Response to Planning Application

From: Arun District Council Greenspace

Application ref: LY/15/21/PL

Description: Erection of a drive-thru coffee shop (Use Class E) with associated infrastructure. This application is in CIL Zone 3 (zero rated) as other development. This application is a Departure from the Development Plan.

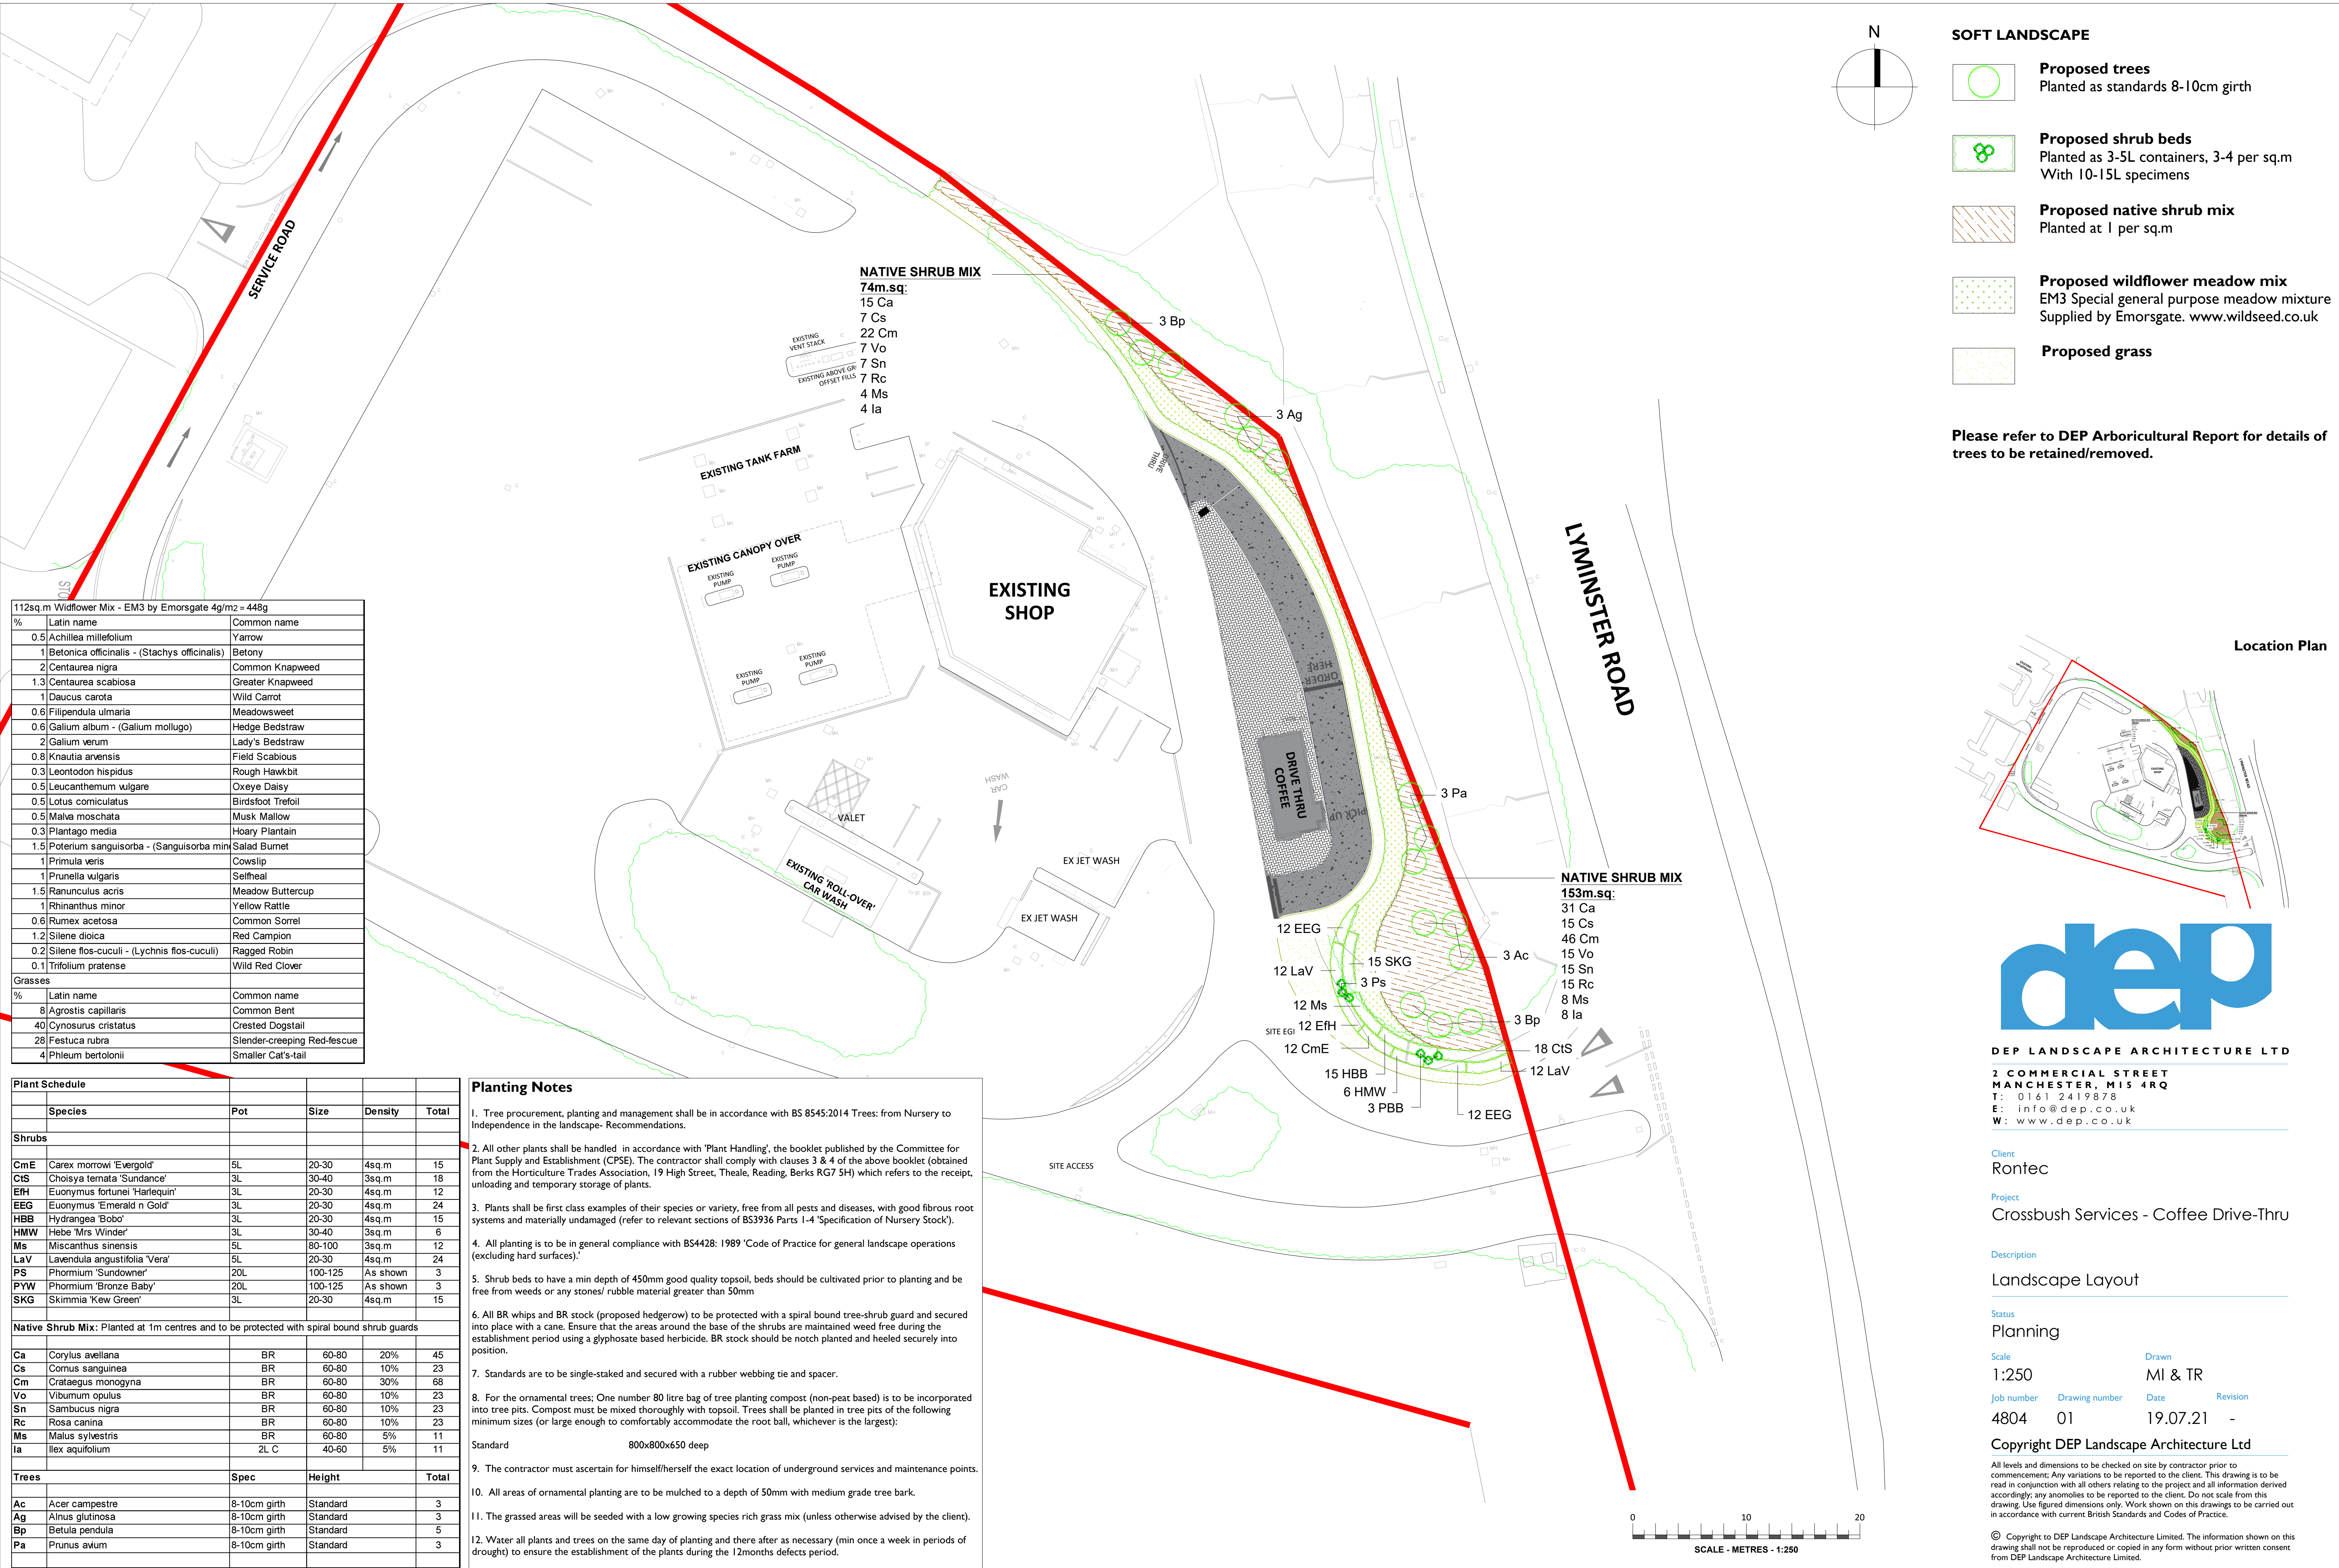
A landscape layout Dwg No 01 Rev - has been submitted with the application which includes landscaping which would appear to be suitable for location and includes tree planting, shrub beds, native shrub mix, wildflower meadow mix and grass. Any tree removals as required to facilitate the proposal would need to be in agreement with the LPA Tree Officer.

The inclusion of native planting would reflect locally found species to enhance potential biodiversity value.

Recommend that the landscape scheme is implemented before occupation and opening of the premise. Maintenance operations to be in place to ensure establishment of the proposed landscape scheme and replacements undertaken within 12 months of completion of any planting failing to thrive.
